From: Jonathan Best <Jonathan.Best@arun.gov.uk>
Sent: 10 January 2025 15:56
To: Planning.Responses <Planning.Responses@arun.gov.uk>
Cc: Simon Davis <Simon.Davis@arun.gov.uk>
Subject: AL/137/24/RES

Land rear of Meadow Way including 24 Meadow Way Westergate.

I have reviewed this application with regards to ecology and Biodiversity Net Gain.

Based on Site Layout 19.dwg
B0457-1500_P4 1501_P4 1502_P5 Drainage Strategy Sheet 1 - 3.dwg

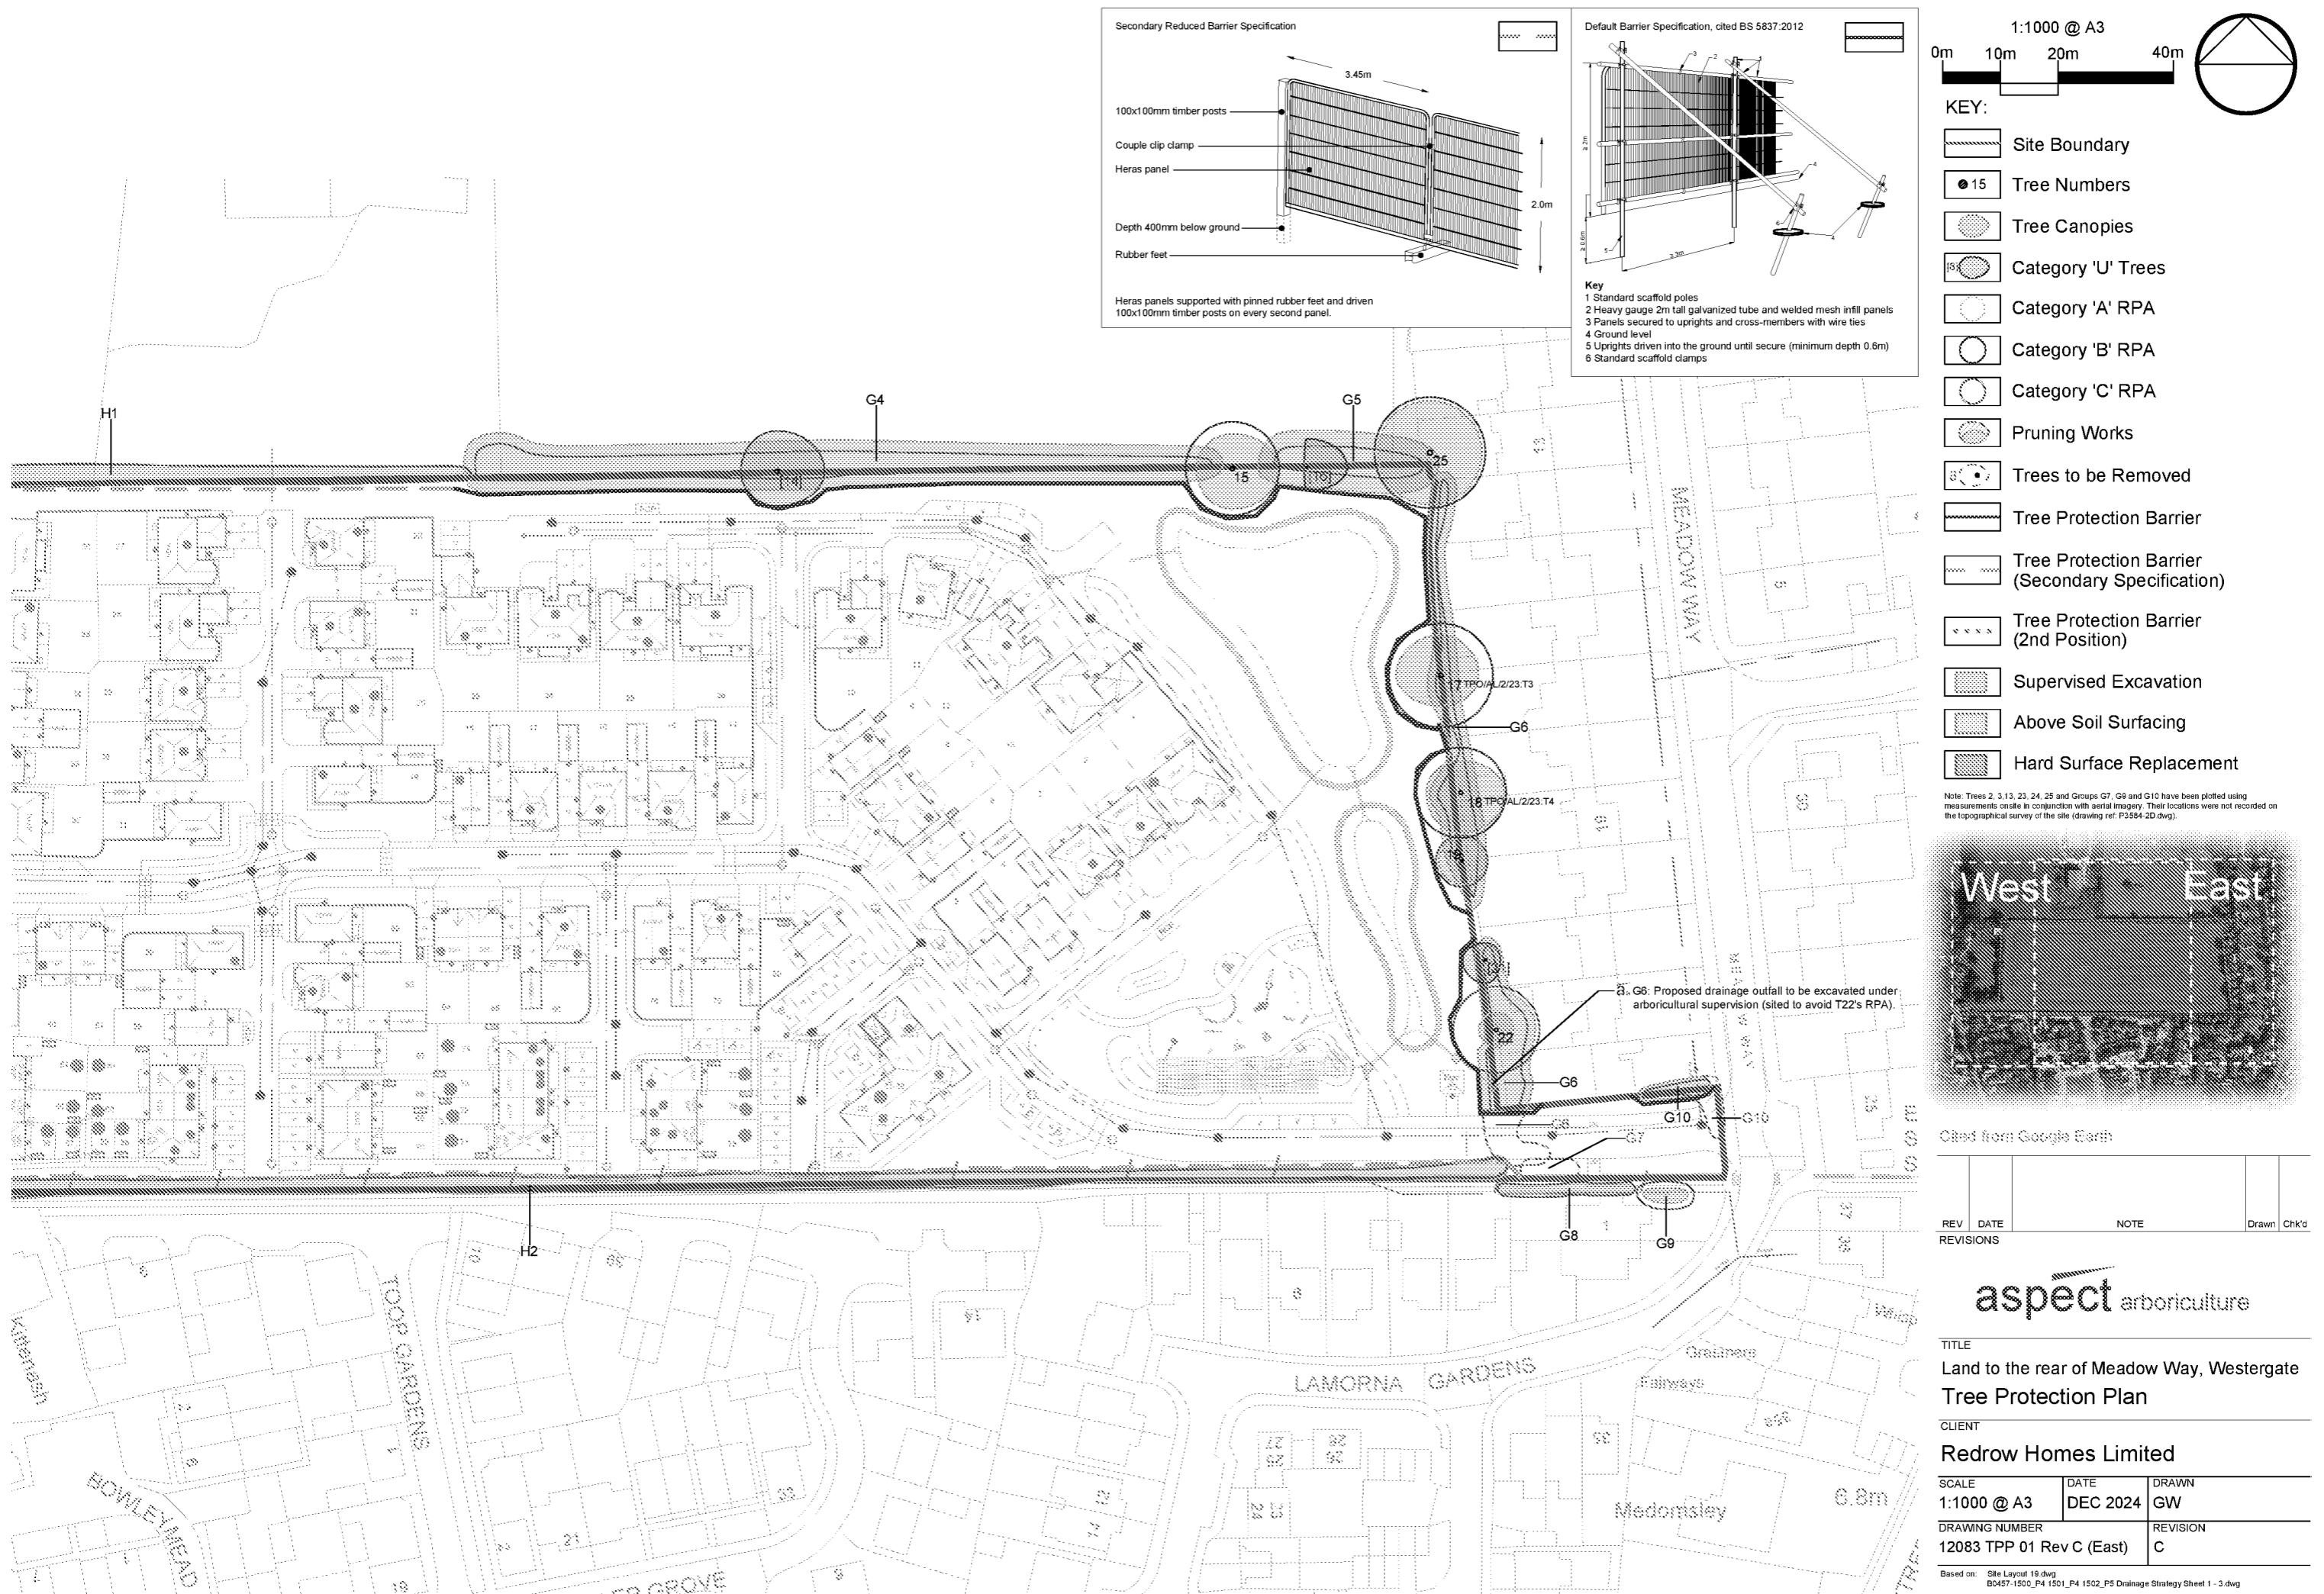
In addition to the RAMs, the retained boundary features should be protected by Heras fencing which would serve as a visual and physical barrier to protect these features from construction related encroachment and consequent accidental impacts during the construction stage.
